**Consultation Response from KC,  
Highways Development Management**

**2023/91658 Jd Sports Gym, 260, Bradford Road, Batley, WF17 6JD**

**Erection of a two-storey commercial and office unit**

**Date Responded: 23-10-2023.**

Project: Land to the rear of JD Gym
 Batley
 Drawing Title: Proposed Site Plan
 Scale: As shown@ A1
 Drwg. Created: 29.05.23

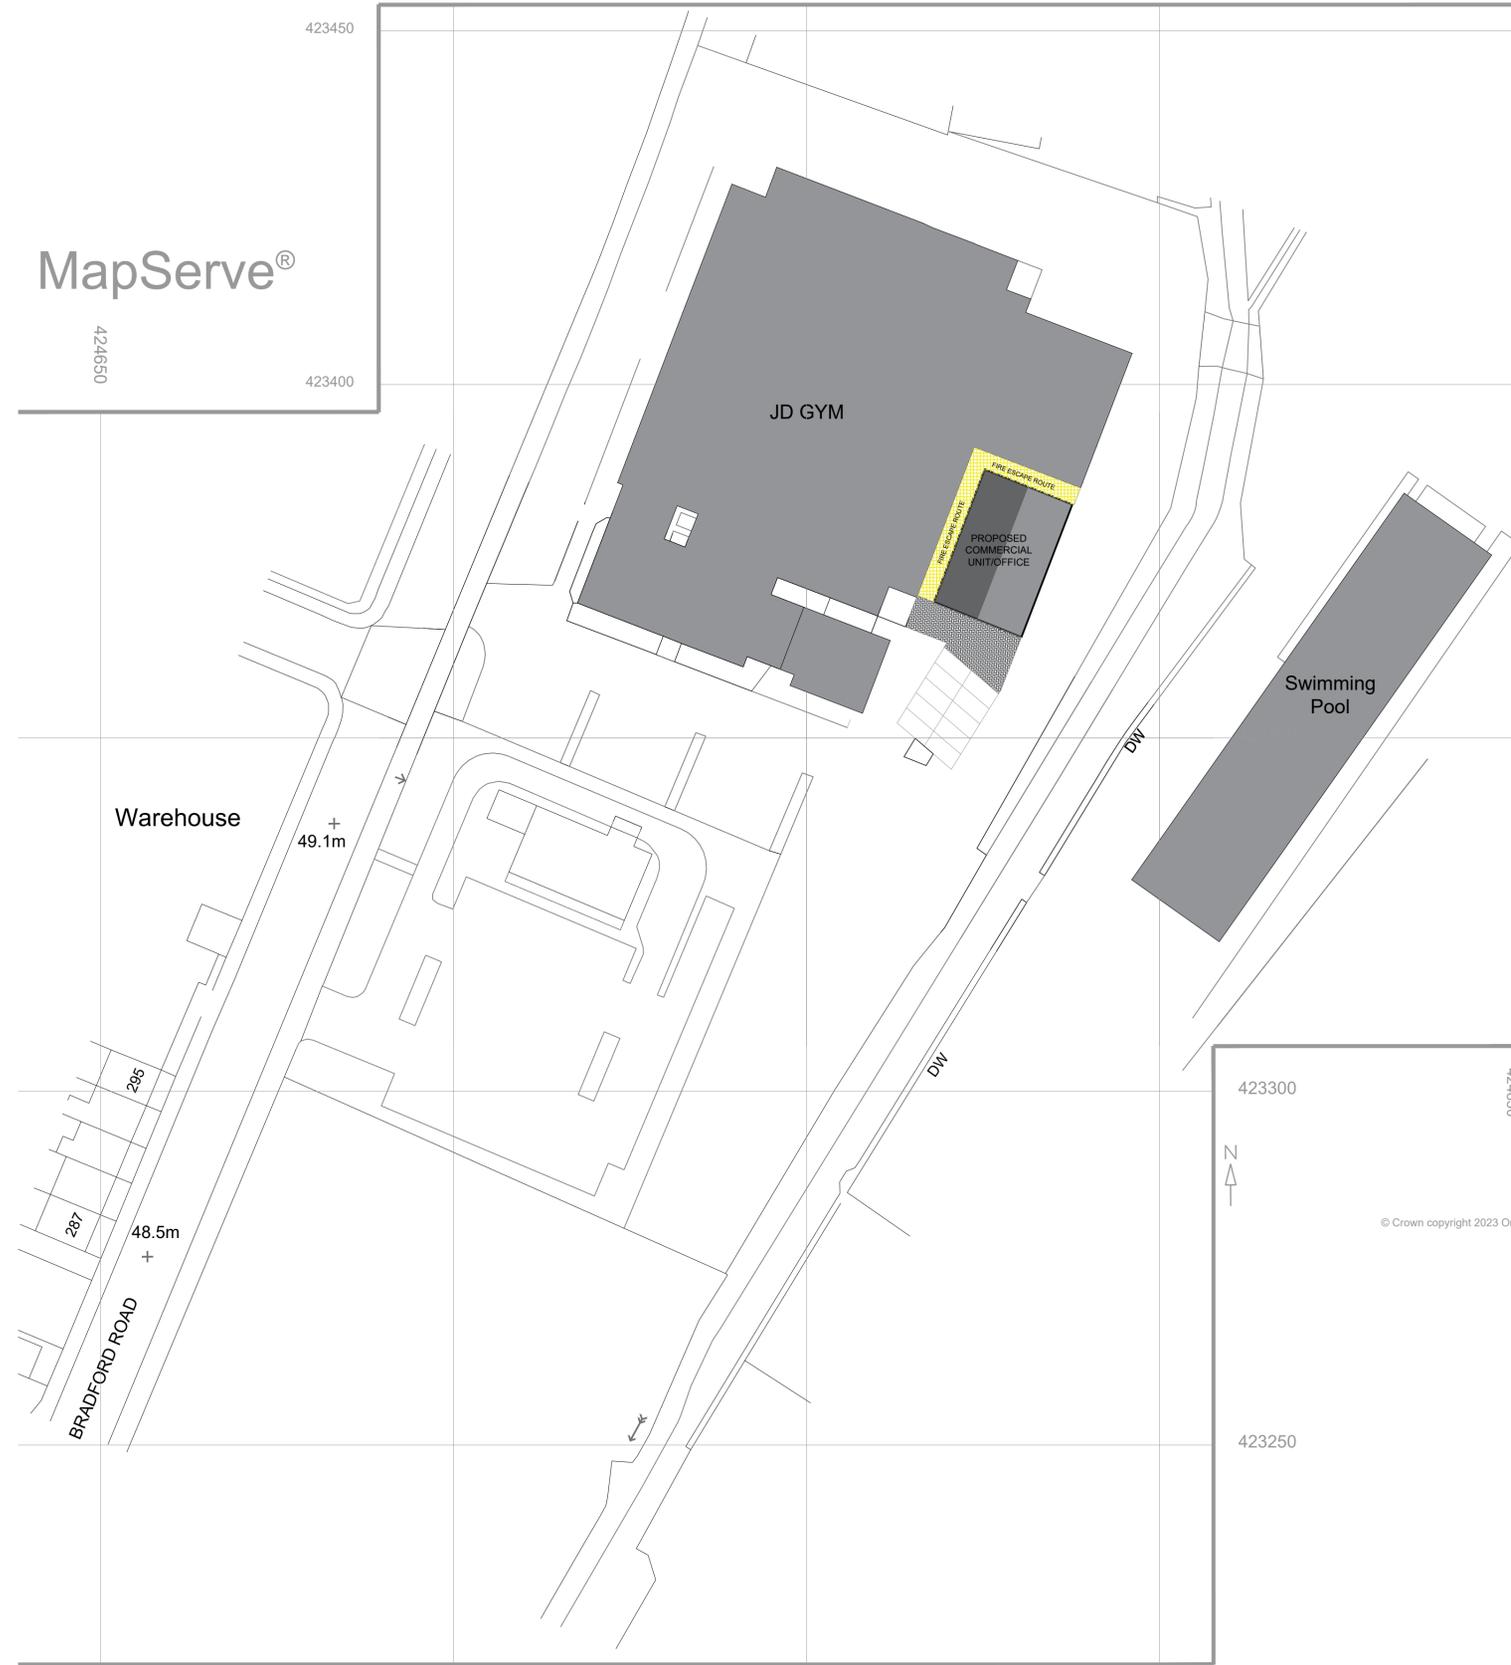
2, The existing parking spaces shown to be retained to south of the proposed building appear to be designed to be accessed via the one-way system in place around the site which will not be the case following the construction of the proposed units. The applicants should either demonstrate by means of swept path analysis that these spaces are accessible or show these spaces to be re-designed.
